LOCAL HIGHWAY AUTHORITY CONSULTATION

Planning Application No.	13/00205/DISC	Planning Officer	Andrew Lewis
Date	21 st October 2013	OCC Officer	Judy Kelly

Location: Heyford Park Camp Road Upper Heyford Bicester OX25 5HD

Description: Partial Clearance of condition 21 of 10/01642/OUT (Commercial Centre)

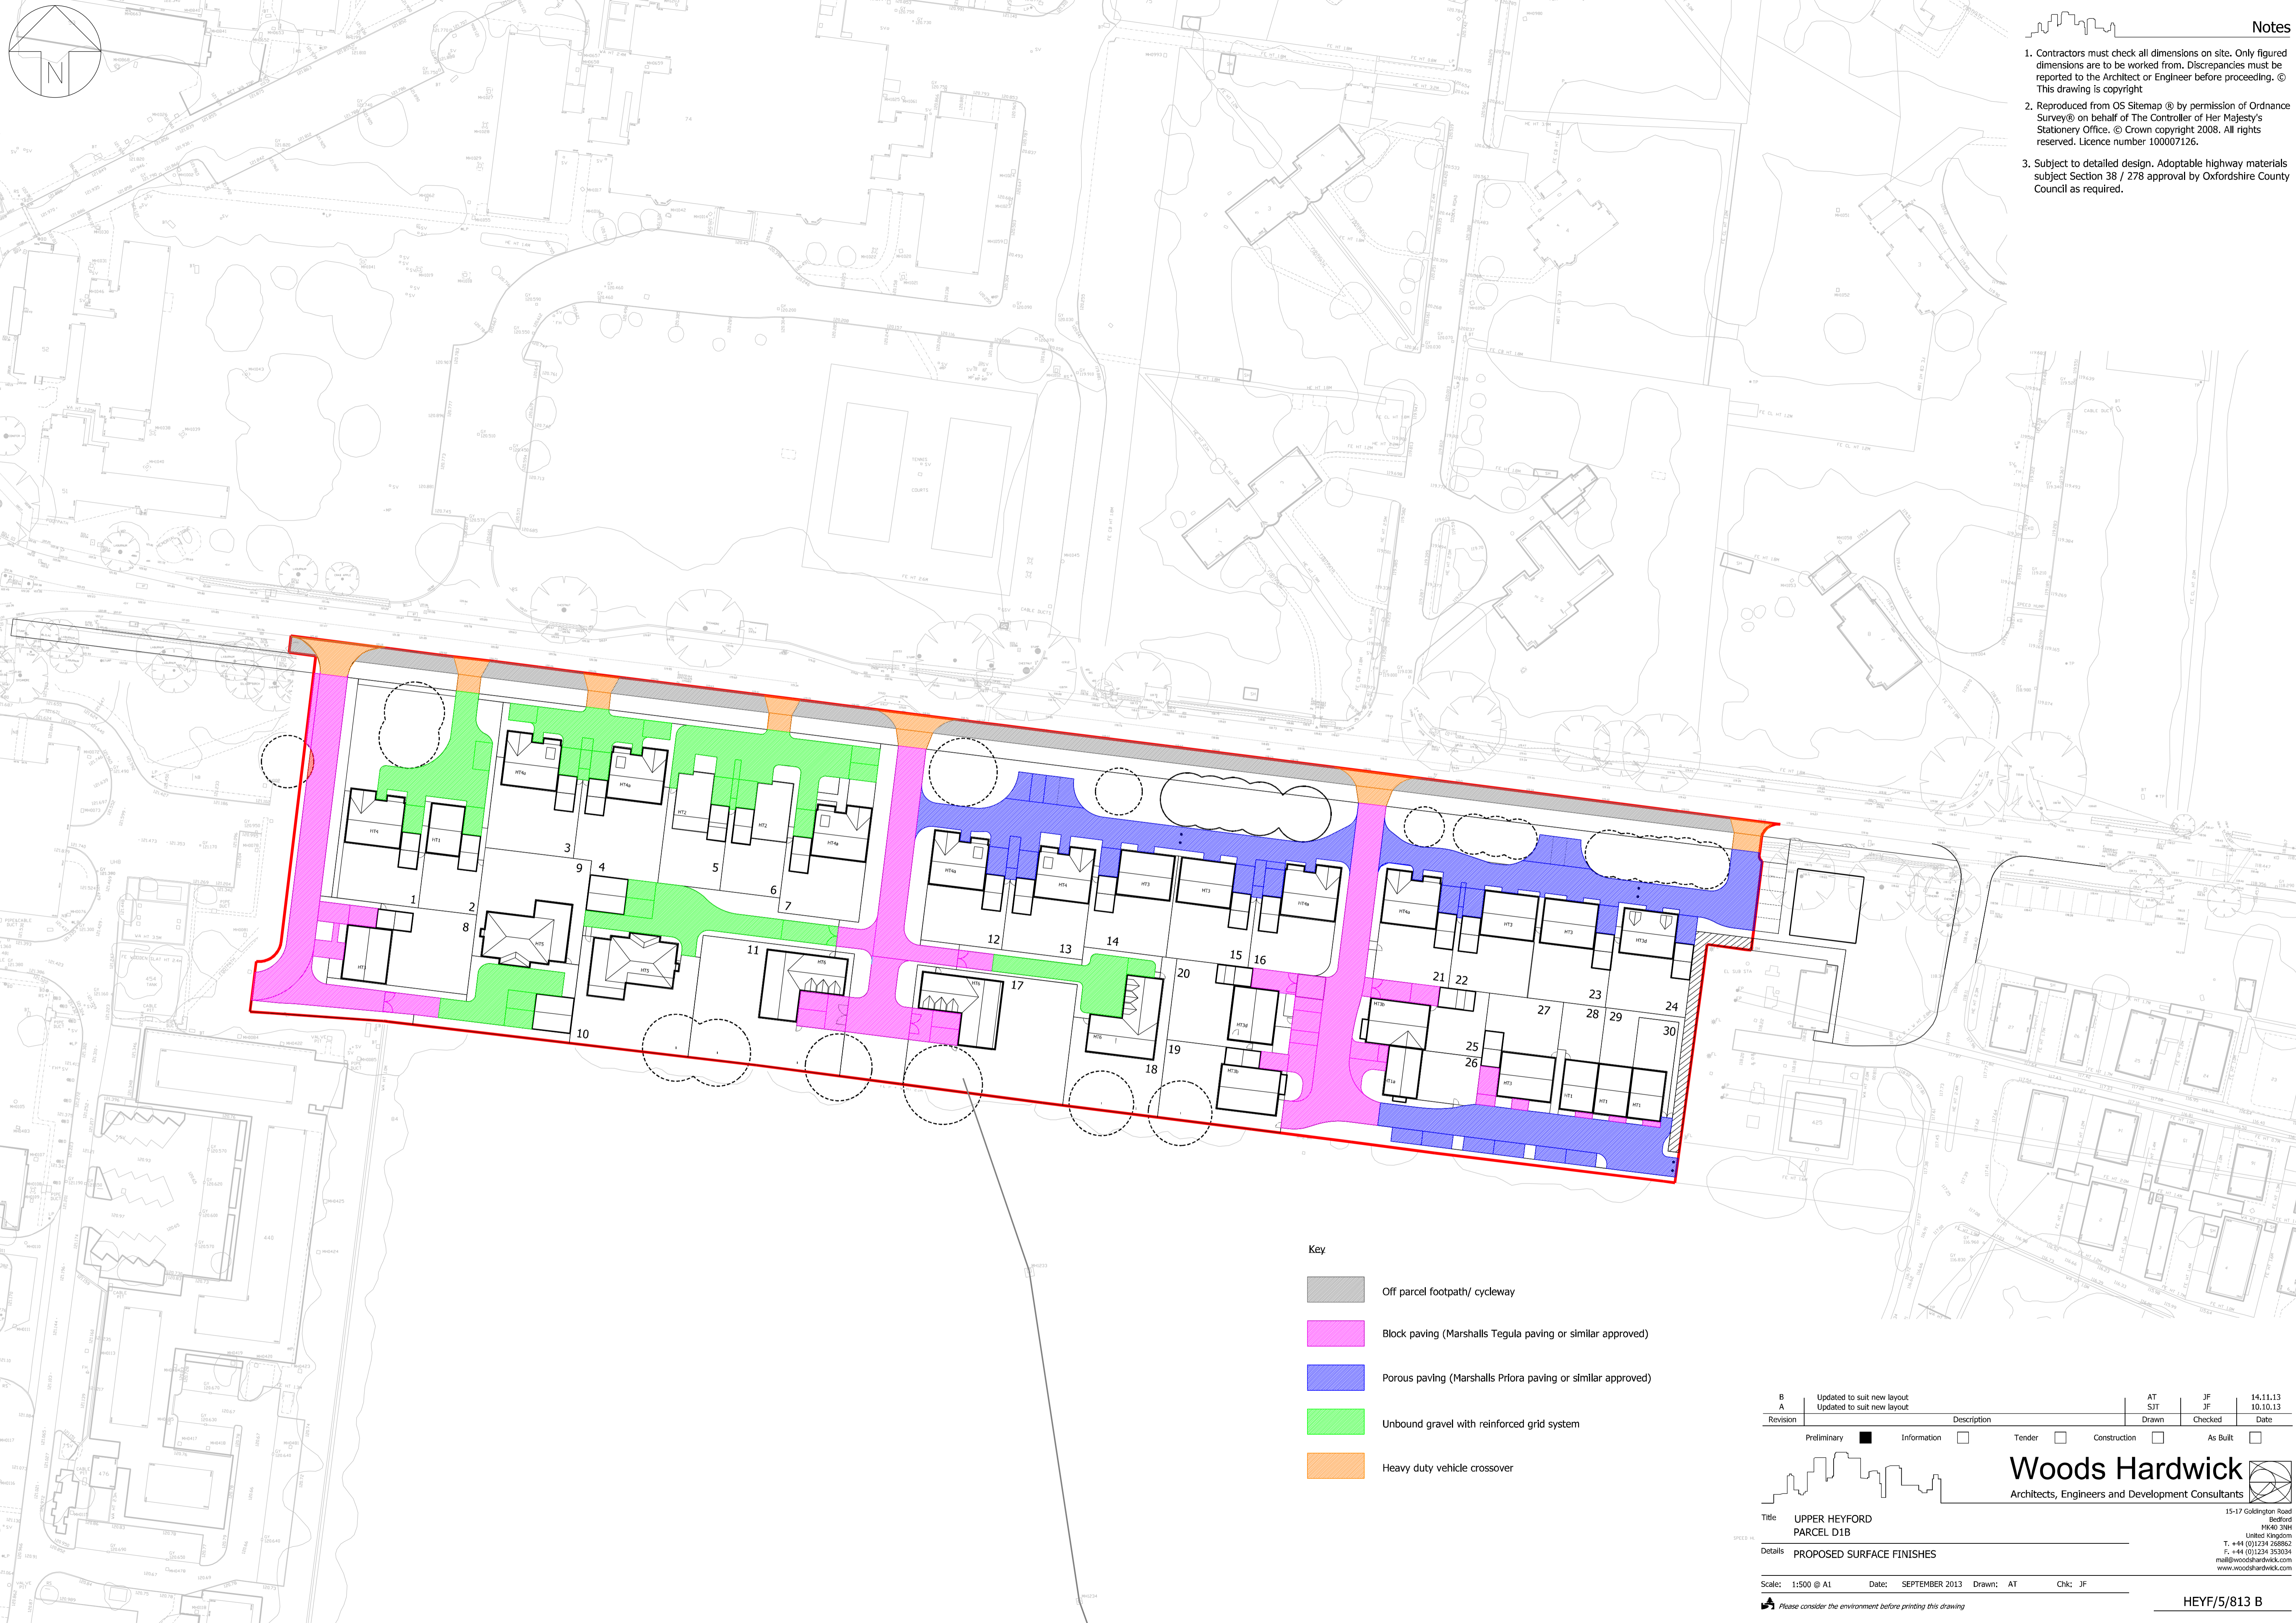
1. I note that the plan provided (ref. HEYF/5/516 B) is scaled at 1:500, therefore does not comply with the scale requirements in the above wording. An amended plan is required.

2. The plan includes a 'squareabout' on the site of the existing Trident roundabout. This feature will need to be the subject of a safety audit, and raises a few queries at this stage. Are pedestrians (including school children) expected to share the carriageway with vehicles and cross this squareabout? What is the feature area in the centre of the squareabout? Can large vehicles track round the squareabout when manoeuvring from south to west without crossing the opposite side of the carriageway? How will vehicles travelling from west to south be prevented from travelling the wrong way around the squareabout and potentially causing road safety conflicts? Are the existing security kiosk barriers to be removed? Further information is required.

3. Block pave carriageway is proposed for the surface of the squareabout and other elements of Camp Road, but this will not be robust enough to accommodate likely future traffic loading. The plan must be amended.

4. The plan is not consistent with the recently approved coach/ car drop-off facilities and pedestrian links for the Free School (ref. plan no. HEYF/5/138). Details are required of the proposed replacement coach laybys, car parking spaces and associated pedestrian links for the Free School, to ensure that this provision is not being removed entirely.

5. Footways shown on the plan (e.g. north side of the access road to the north of Camp Road) do not appear to comply with the required two metre width. Please amend.

6. Currently, pedestrians are able to cross Camp Road on either side of the roundabout south of the Trident roundabout. What replacement pedestrian crossing provision is proposed under the new scheme, as there appear to be no details shown on plans?
7. I note that the parking spaces shown to the north of the local centre appear smaller than the recommended dimensions of 2.5m x 5m, and do not include any disabled parking spaces. This must be amended.
8. What is the purpose of the layby shown on Camp Road nearest building 100? A bus stop and shelter is already shown on plans to the west.
9. A signage strategy for the scheme will be required, including details of the bus only route and any other traffic restrictions.
10. All works once approved must be carried out to OCC specification and a Section 278 Agreement will be required (Road Agreements Team).

I recommend that my above comments are addressed and that amended plans are provided. I welcome the opportunity to comment further on plans when these are developed in more detail. For example, it would be good to see the layout of the commercial centre and advise on matters such as the pedestrian links and parking provision relating to this.
